Office of
Environment
& Heritage

DOC17/437565
SSI 8285

Notice of Exhibition - Parramatta Light Rail Stage 1 (SSI 8285)

ATTACHMENT 1 – Office of Environment and Heritage comments on Parramatta Light Rail Stage 1 (SSI 8285)

**Construction Airborne Noise Contours
Worst Case Daytime
Construction Noise Predictions**

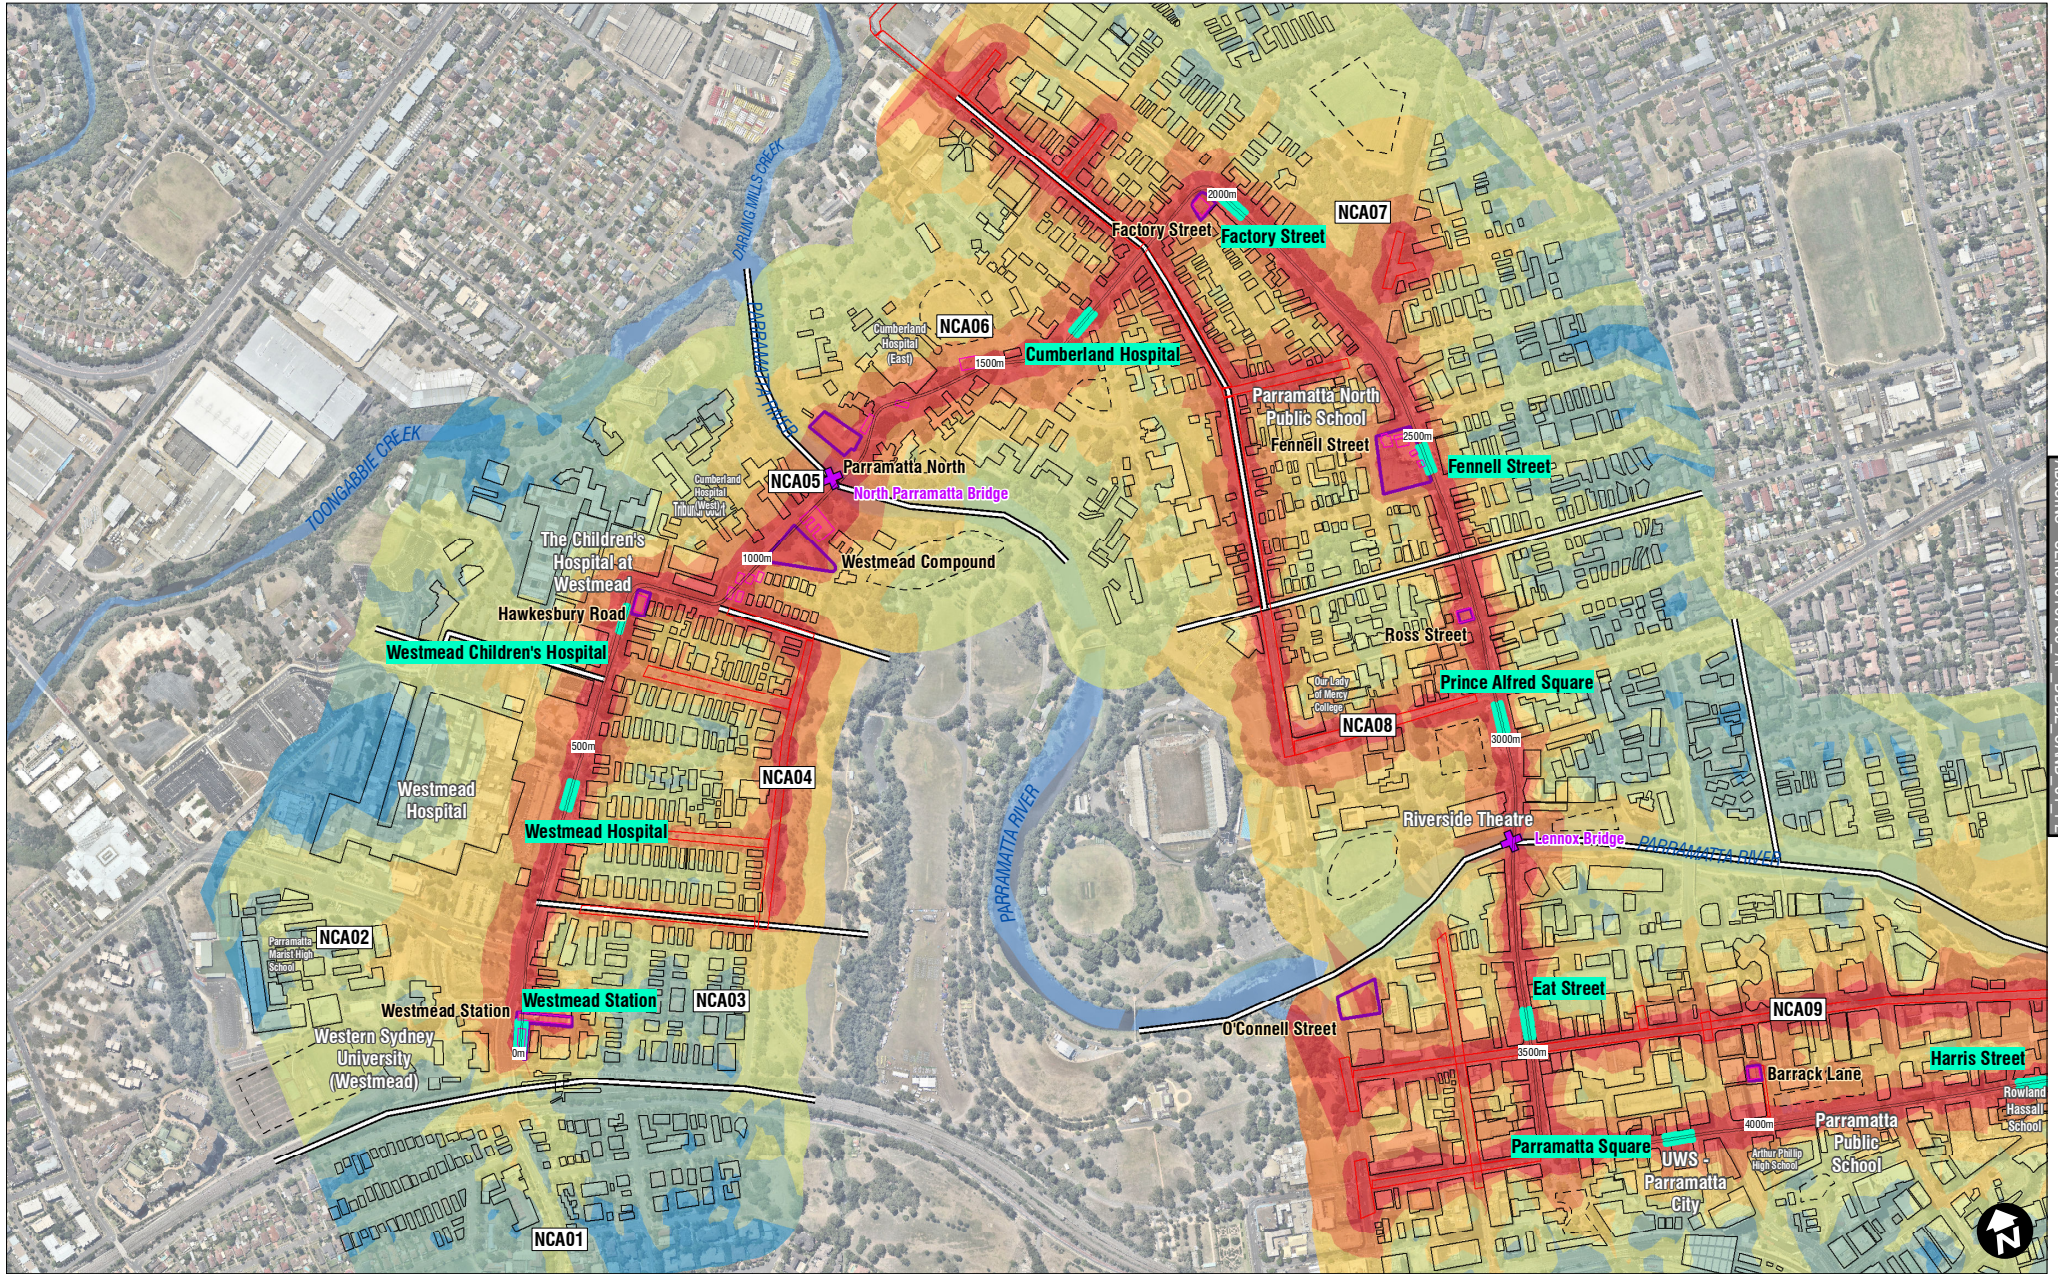
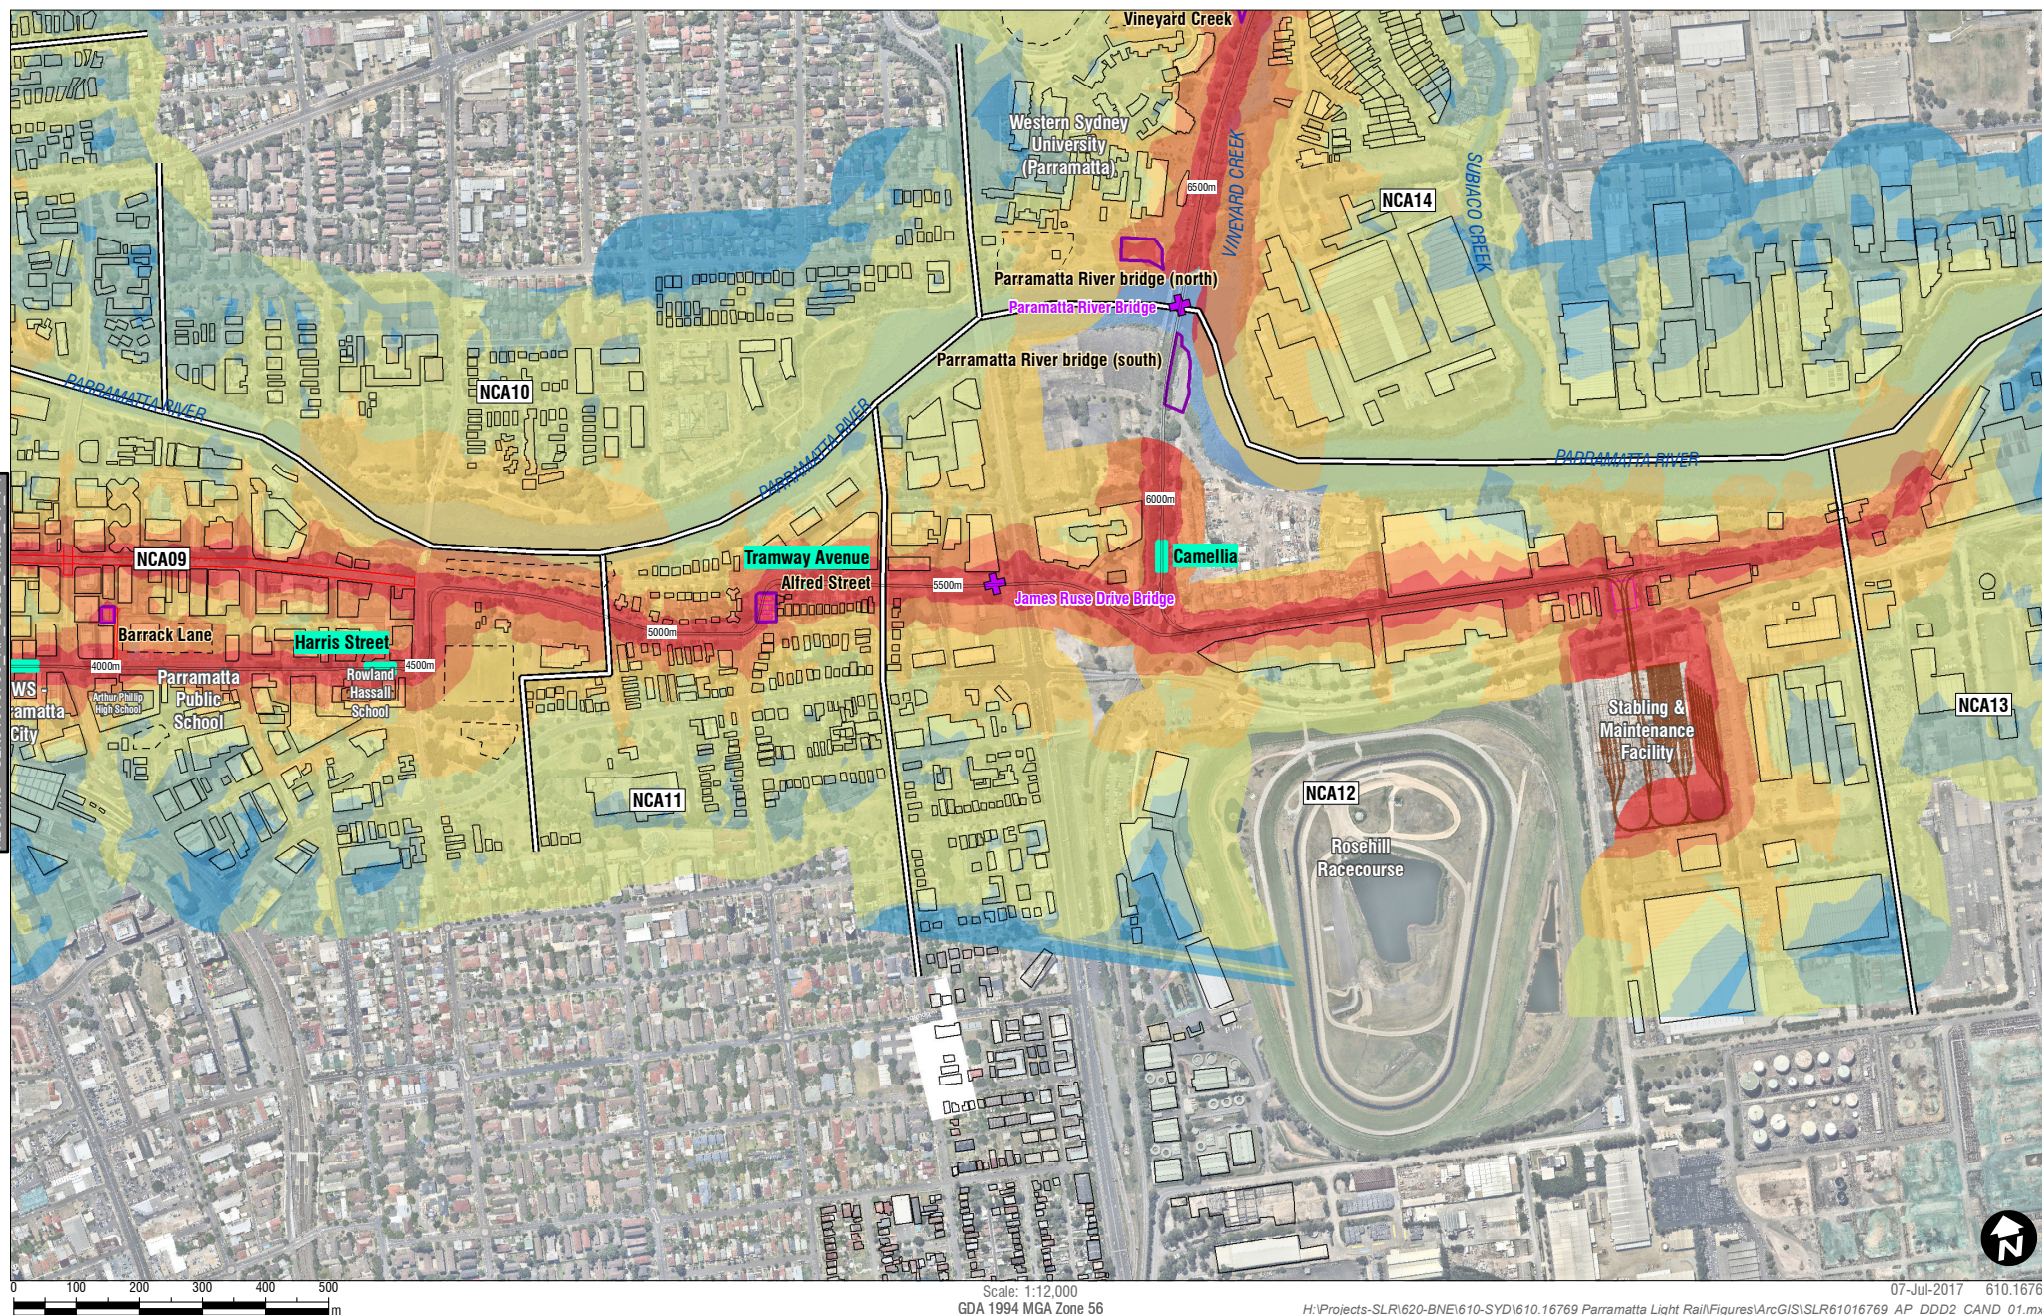
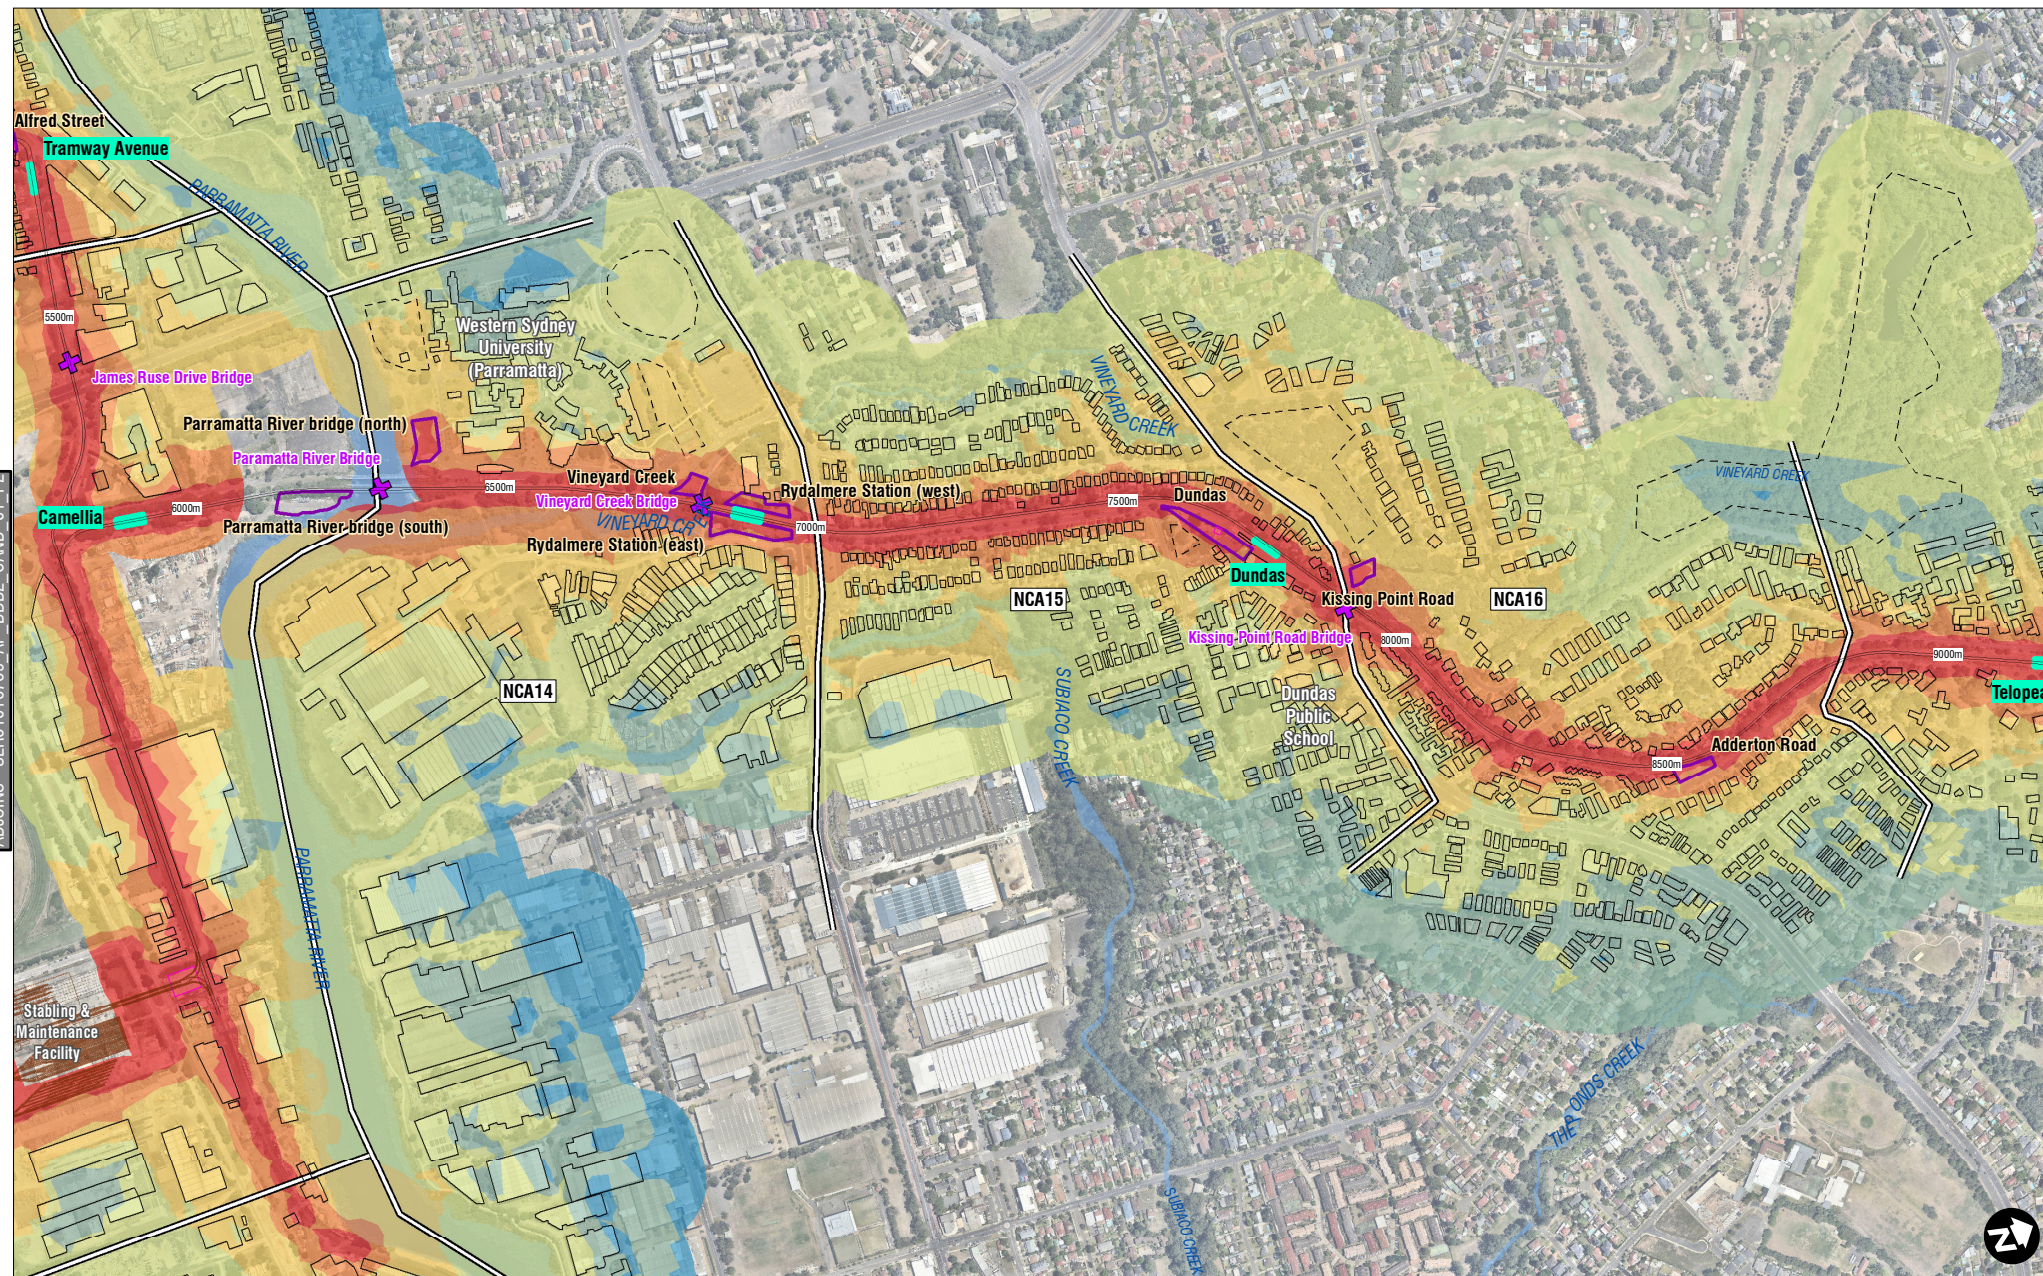
The BAR states that GHFF are tolerant of some level of ongoing noise and light impacts, which OEH agrees with. However, it is the impacts from construction noise associated with this proposal that OEH considers are of most concern. The BAR mentions construction noise impacts in Section 8.6.1.2, but the BAR concludes that these will not be an issue as the noise will be adequately buffered by vegetation and buildings. OEH notes that the Noise and Vibration Impact Assessment prepared by SLR Consulting does not include objective measurement of potential noise that could reach the camp.

The BAR also states that "Although noise from the Bridge Street bridge area of the construction boundary may reach the camp more directly, the highest noise levels are considered unlikely to reach levels for extended periods that other GHFF camps are accustomed to at the nearby Clyde camp or those at Singleton and Balgowlah." OEH does not consider this a fair comparison, as the GHFF camps at Clyde, Singleton and Balgowlah are not accustomed to the very loud, sometimes sudden types of noise related to construction, they are accustomed to the lower, more predictable operational noises. In fact, there is anecdotal evidence that the Clyde camp, as well as other camp sites (e.g. Kurnell) did temporarily disperse because of noise from adjacent construction projects. Therefore, OEH considers that given the high risk that the construction noise impacts could disperse or move the camp to a less suitable location, that the BAR should include a more thorough noise assessment, which quantifies potential impacts and demonstrates, through comparisons with other similar situations and projects, that the GHFF will not be impacted by this noise.

Section 8.6.1.6 of the BAR states that a biodiversity management plan will be prepared for the project to manage the natural environment during the construction phase of the project, which will include strategies to minimise impacts on the GHFF camp at Parramatta Park. OEH supports this but considers that the biodiversity management plan should also include contingency measures that will be undertaken if the mitigation measures have been unsuccessful in mitigating impacts, i.e. if the camp disperses or shifts location as a result of the works. It is noted that the Parramatta Park camp has shifted recently, which is likely due to construction noise associated with the Parramatta North Urban Transformation site and Western Sydney Stadium.
